**J.S. THOMPSON**  
**ENGINEERING, INC**

June 19, 2024

The plan was reviewed for lot #24 Tobacco Road subdivision in Angier, North Carolina to address the beam in the second floor system noted by the inspector.

S-3d
SECOND FLOOR
FRAMING PLAN

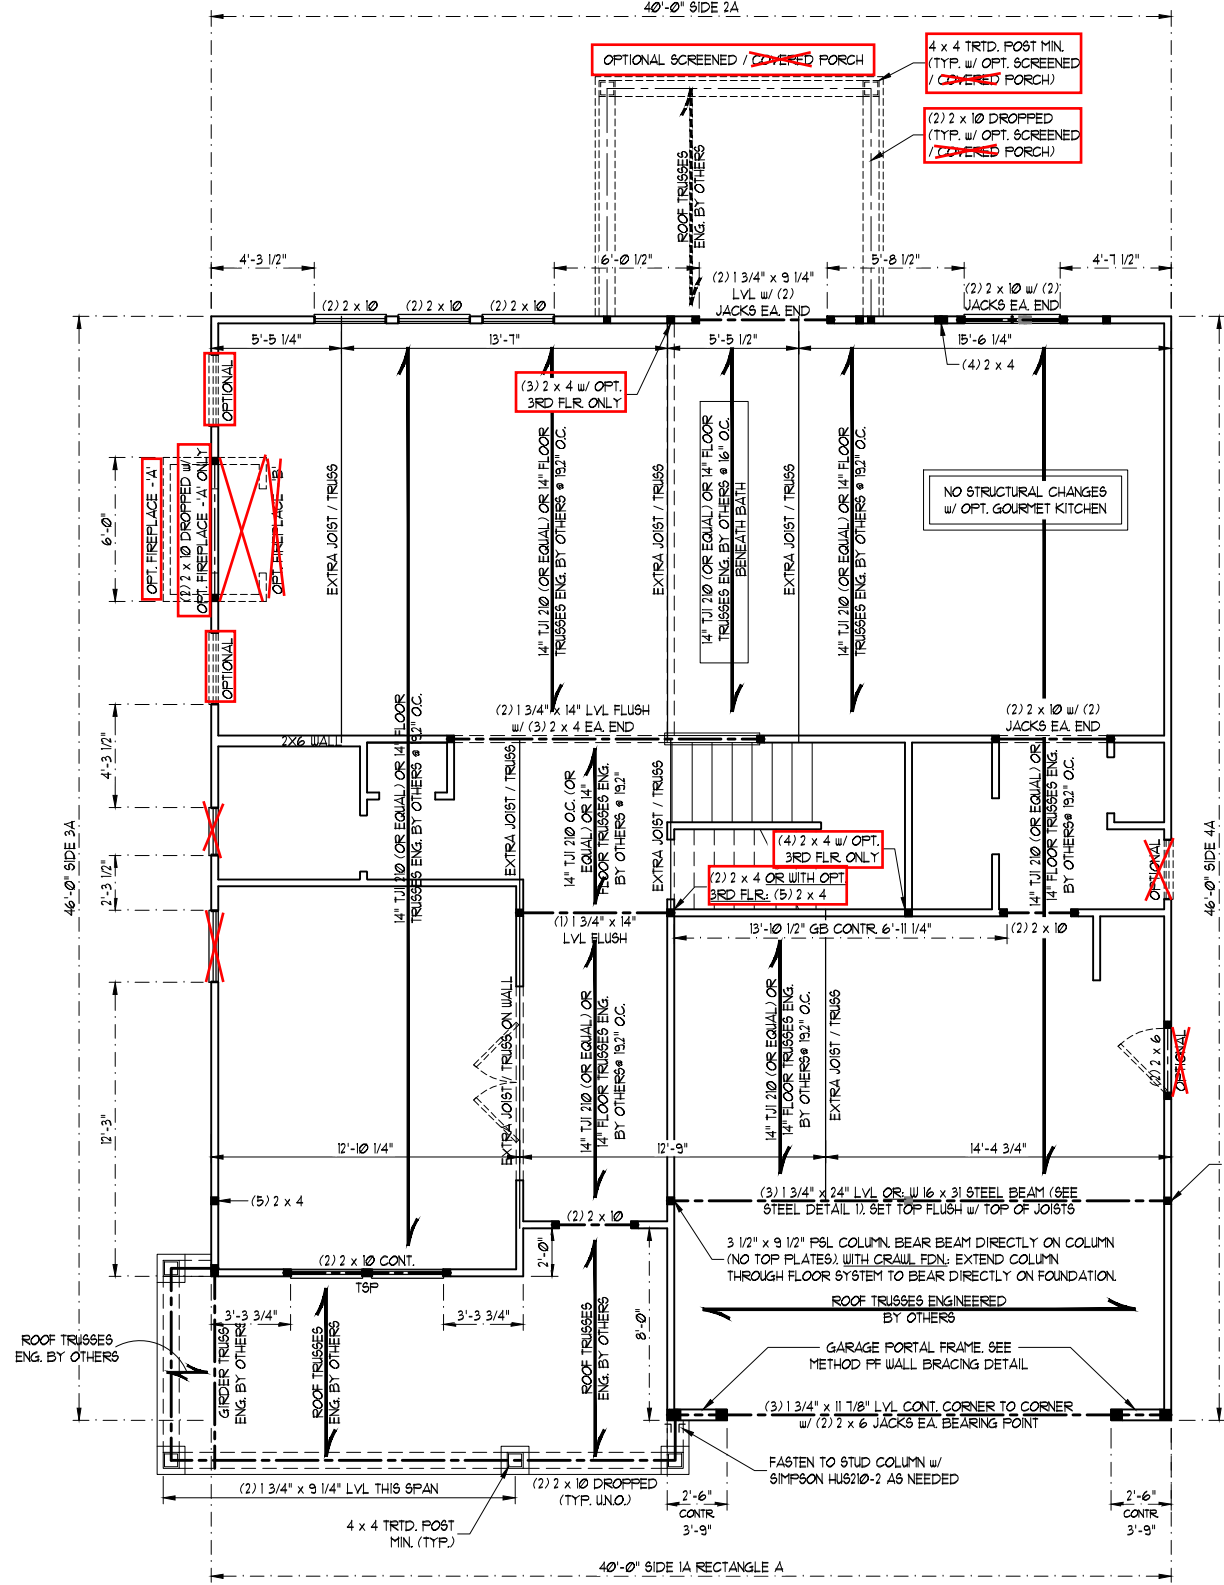
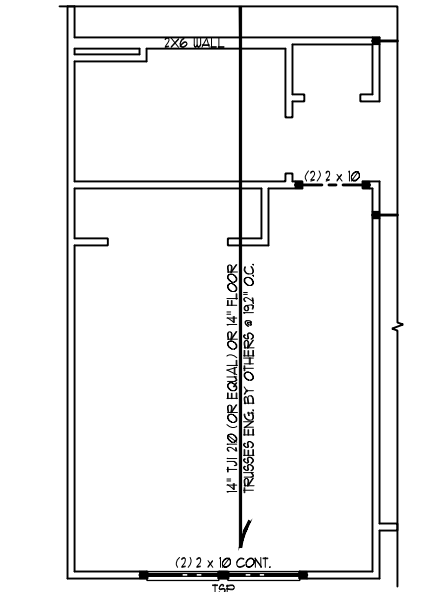
The (2) 1 3/4" x 14" LVL beam adjacent to the stairs with several holes drilled at the bottom edge for wires will provide the required support for all applied loads. No modification is required.
